Consultation Response from KC, Highways Development Management
2026/90331 5, Park Riding, Northgate, Honley, Holmfirth, HD9 6QL
Change of use and alterations to convert residential annex to 1 dwelling
Date Responded: 03/07/2026 Responding Officer: CNB Responding Ref: K3-50/32
This application is for the change of use and alterations to convert a residential annexe to a two-bed detached dwelling within the grounds of an existing dwelling with a shared access on to C574 Northgate a 30mph tertiary distributor road of approximately 5.3m width with a footway on the side of the application site and limited street lighting present. There is a PROW footpath HOL/15/70 located to the northeast of the application site that terminates at the site access. This application was initially discussed at Highway Surgery where the HDM team had concerns with the proposals given the constrained layout of the site and access and presence of the PROW. The application was accompanied by a Highways Note dated 3rd Feb 2026 from Aimee Thompson Transport Planning. The proposals would remove the annexe designation from the proposal site and this would become an independent detached dwelling and this would inten

Drawing Title
Proposed Site Layout Plan

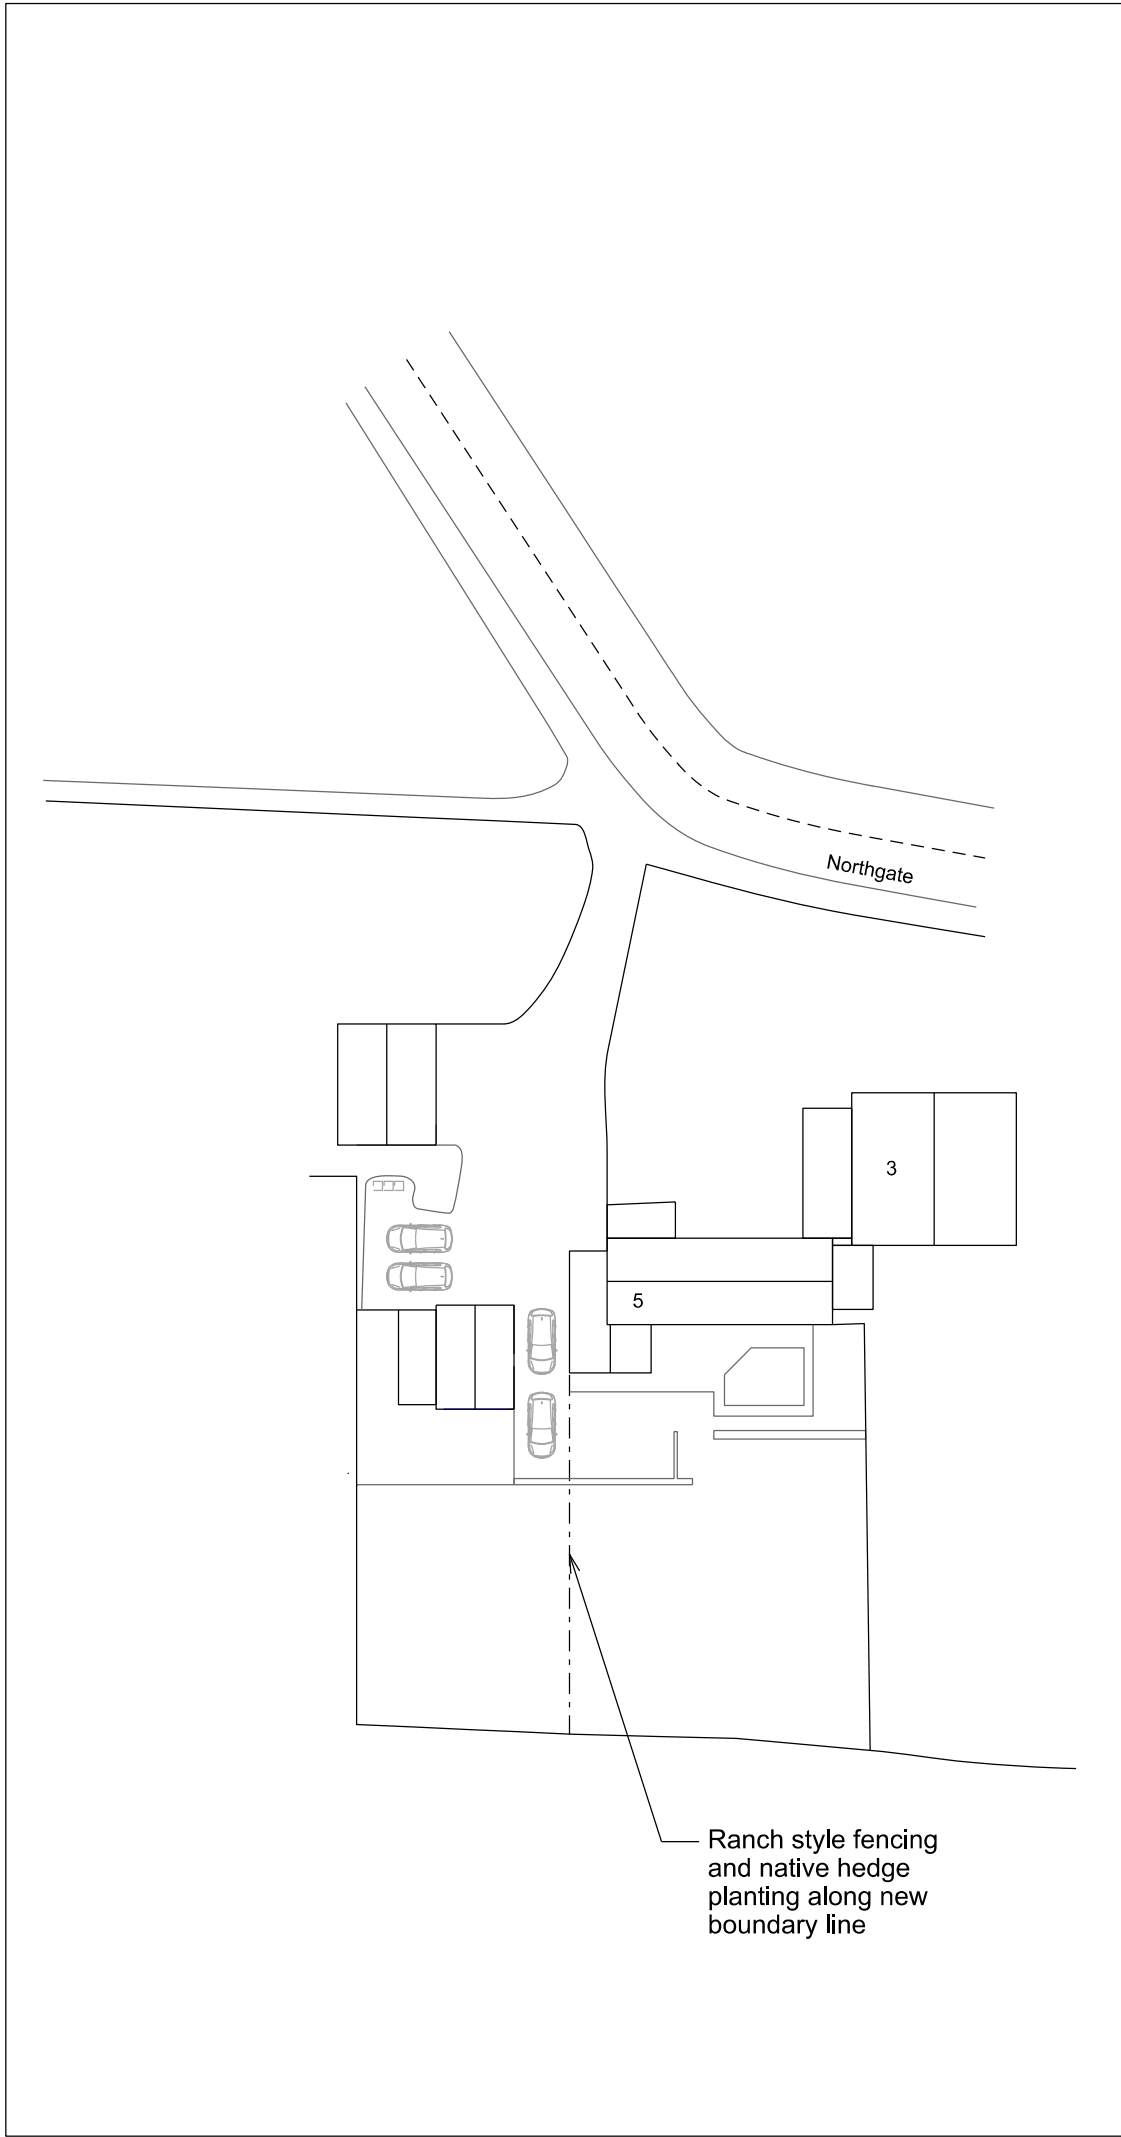
We would also need to see the location of a bin collection presentation point clearly indicated on a drawing and this should be located where it is accessible to collection crew, but where it won't obstruct either the parking spaces, access or turning area or the footway or highway for road safety reasons.

P003

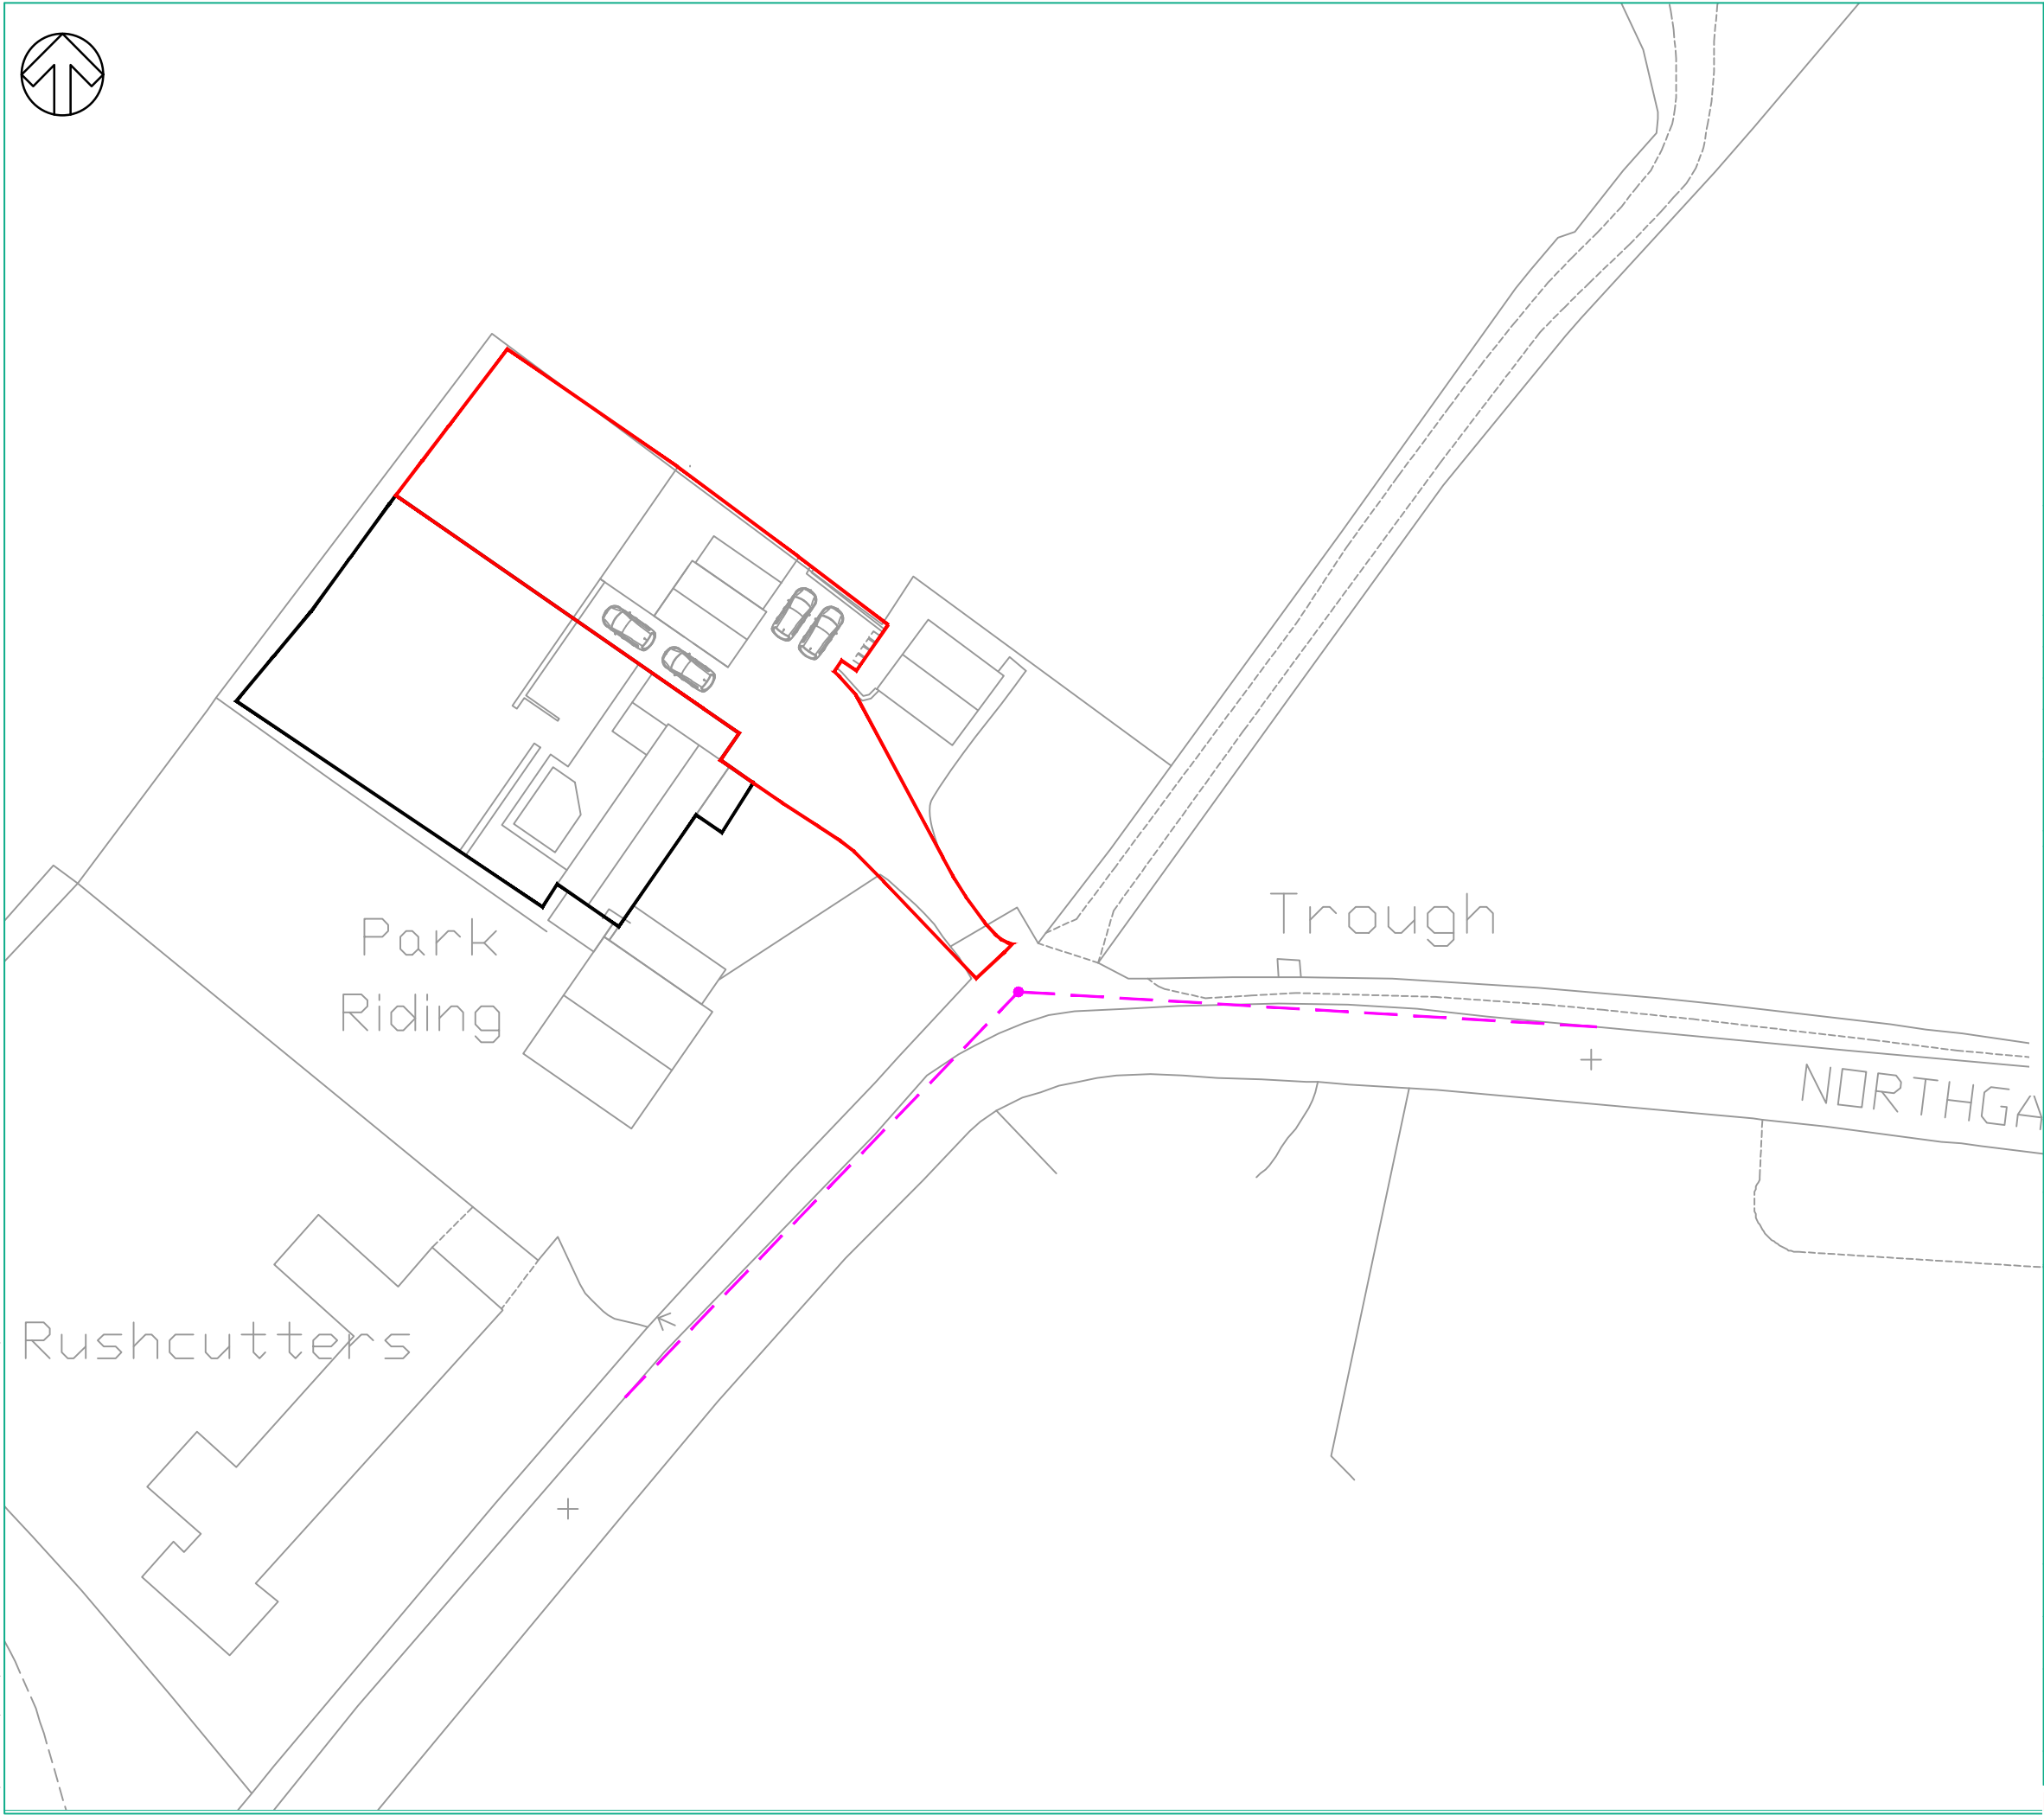
all the parking spaces, although there may be issues if the rear car in the tandem parking spaces needs to leave as there is very limited space to temporarily relocate the front car and still allow easy manoeuvring and access. No swept path analysis was provided for the garage and parking spaces for No 3 Park Riding, although there looks to be sufficient space to allow turning and so this is not a concern. We would like to see the drawings marked with an area of shared turning to protect this space from obstruction to guarantee that all cars can turn and manoeuvre on site so they can enter and exit the site in forward gear for the lifetime of the development.
